PROJECT TITLE
Constitutional and Marksheffel

A200

A200

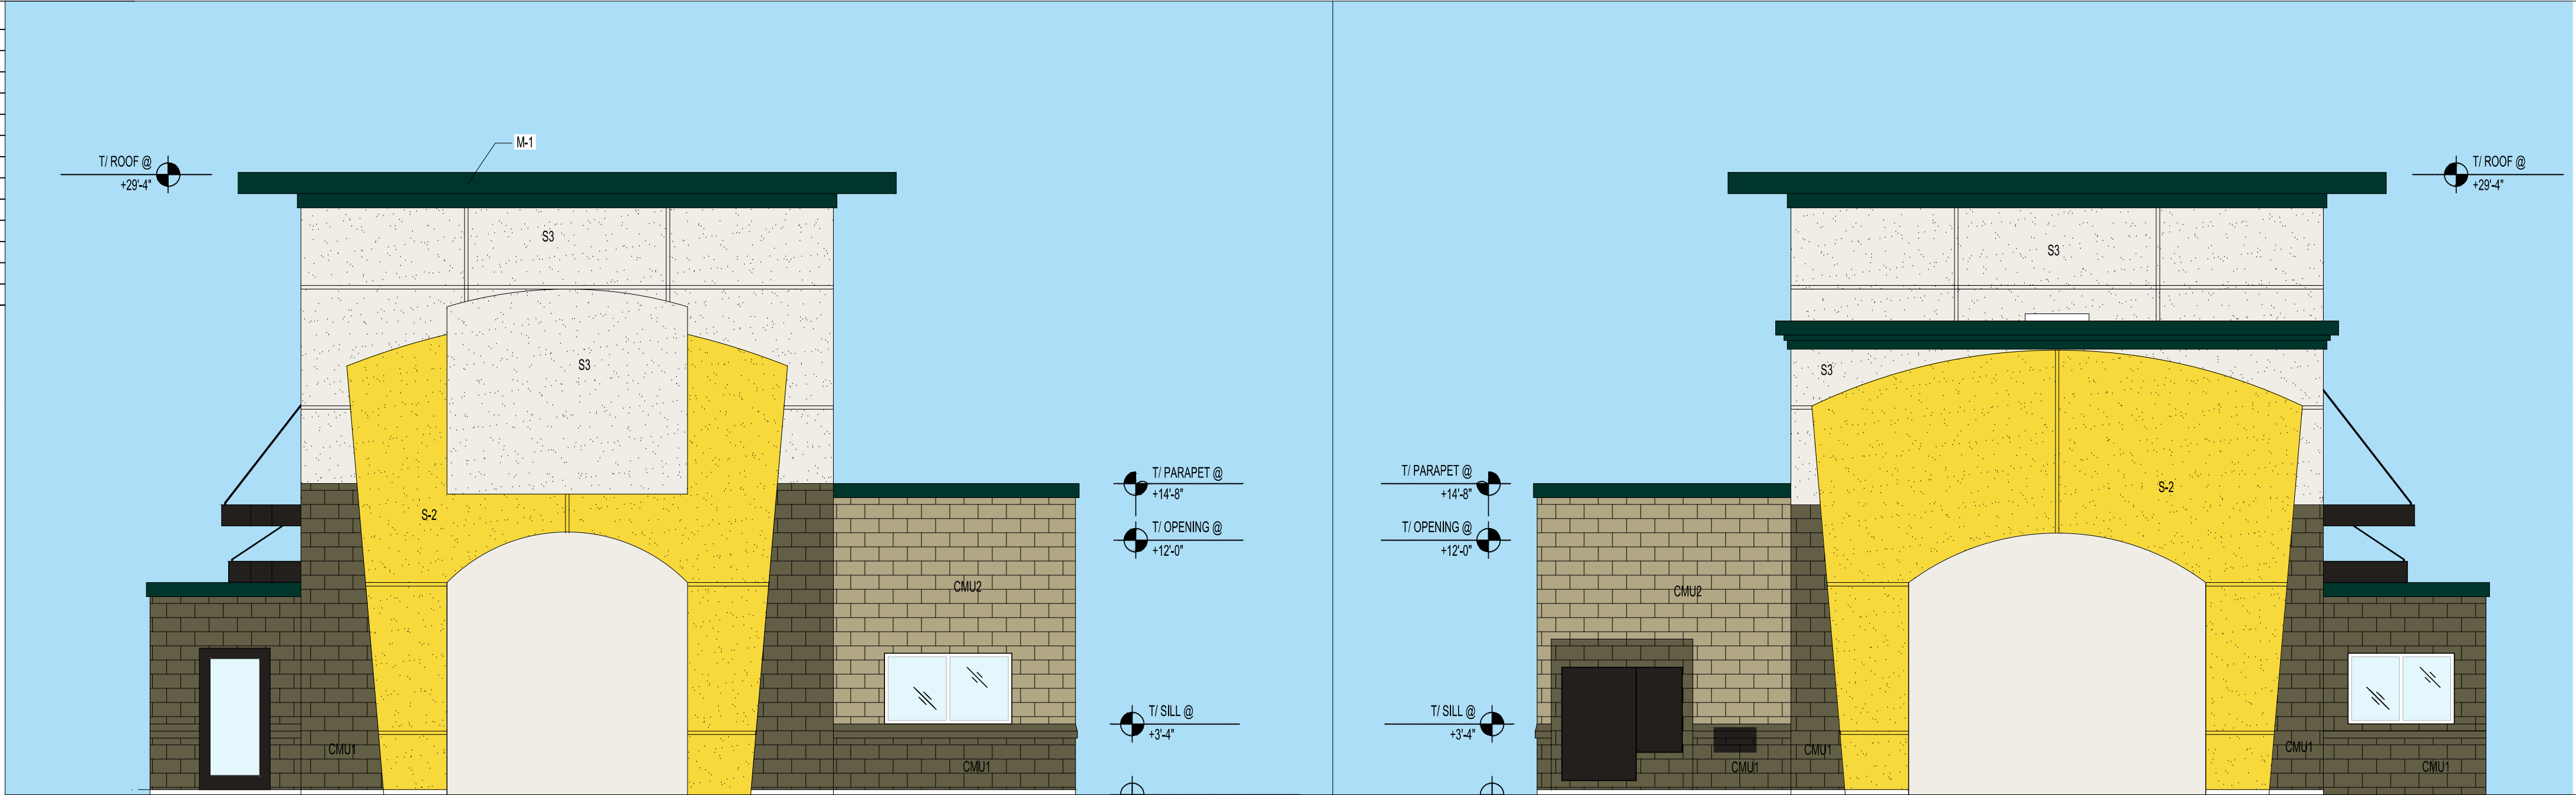
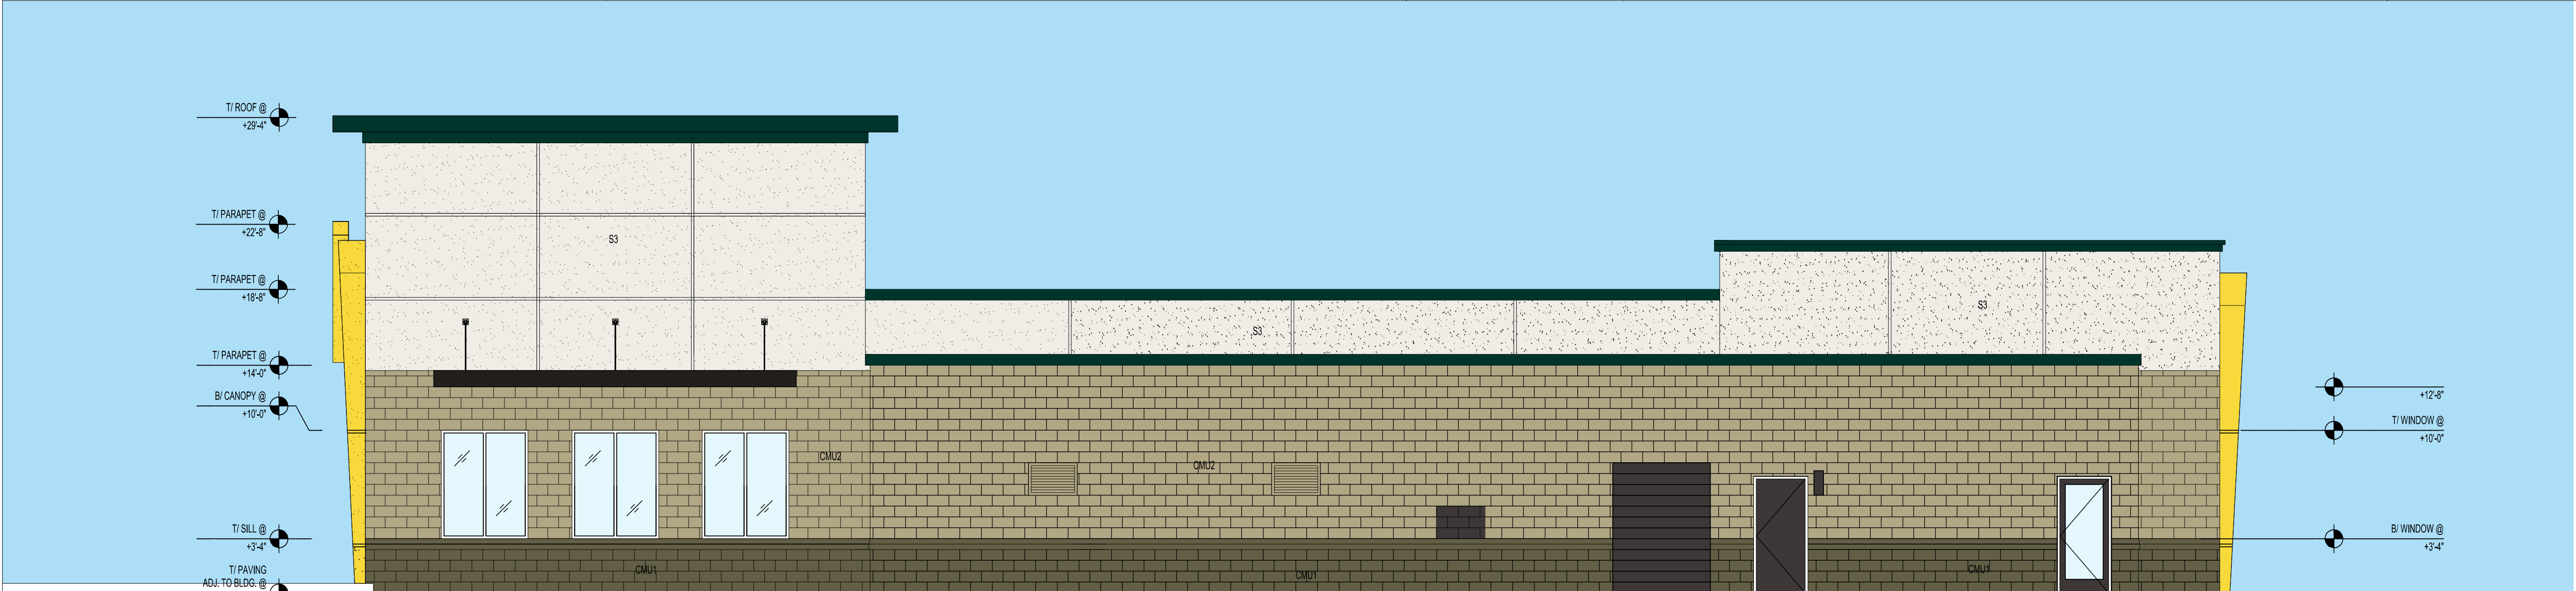
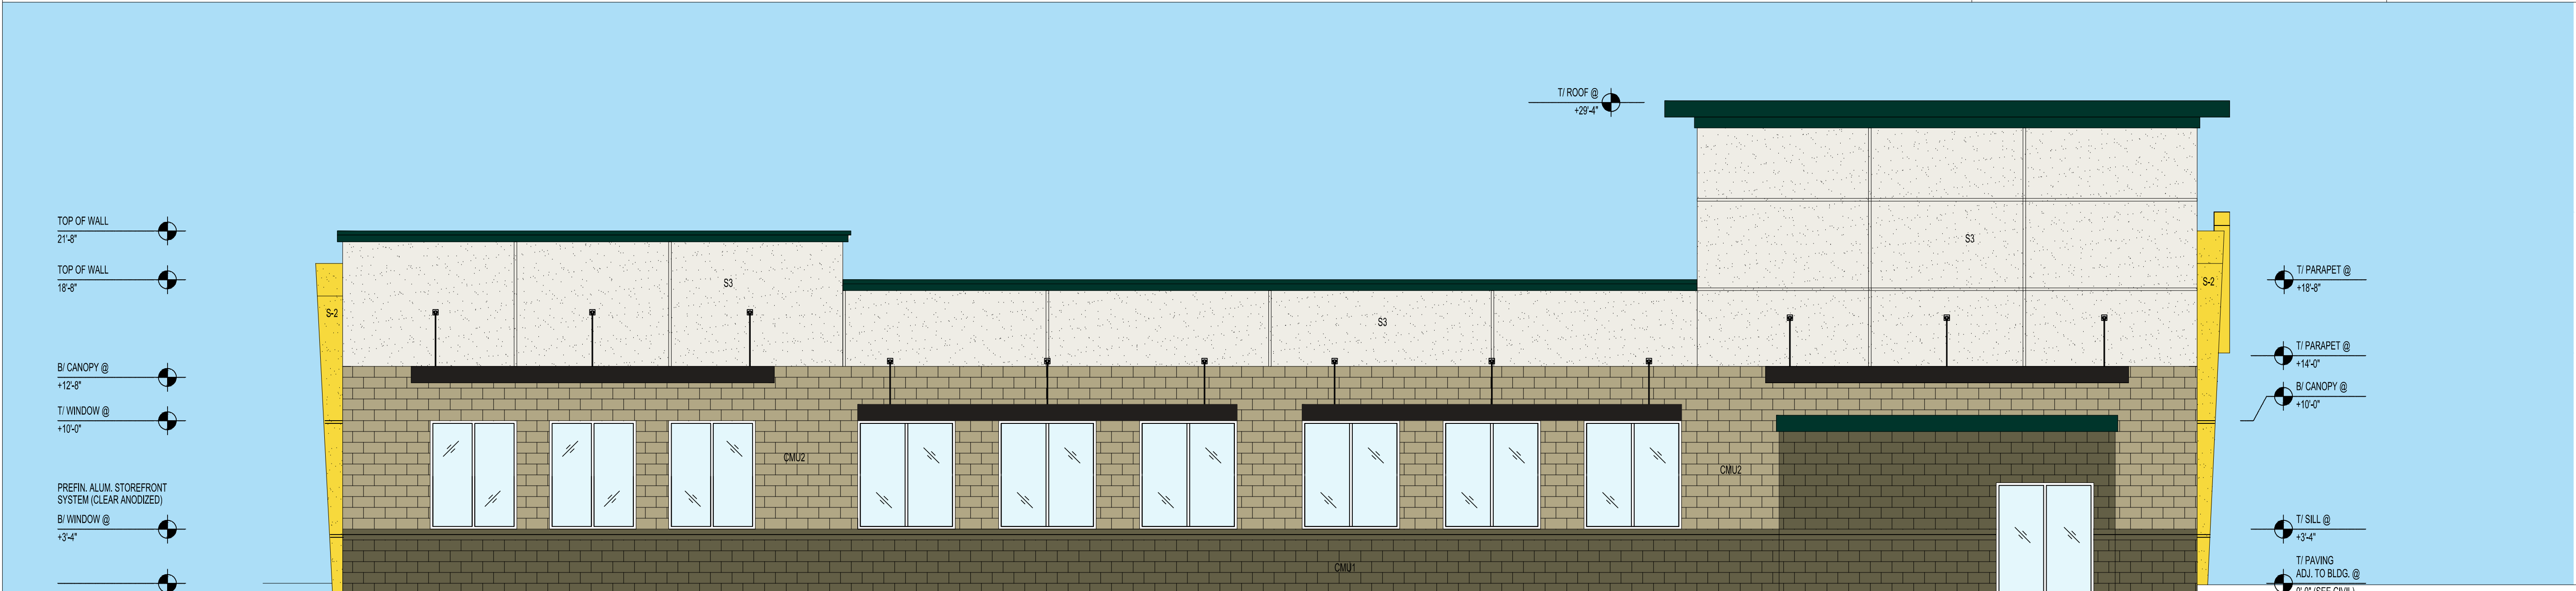
Elevations of the structure are required on the plan to verify the height restrictions are met

Please include elevations of the vacuum canopy
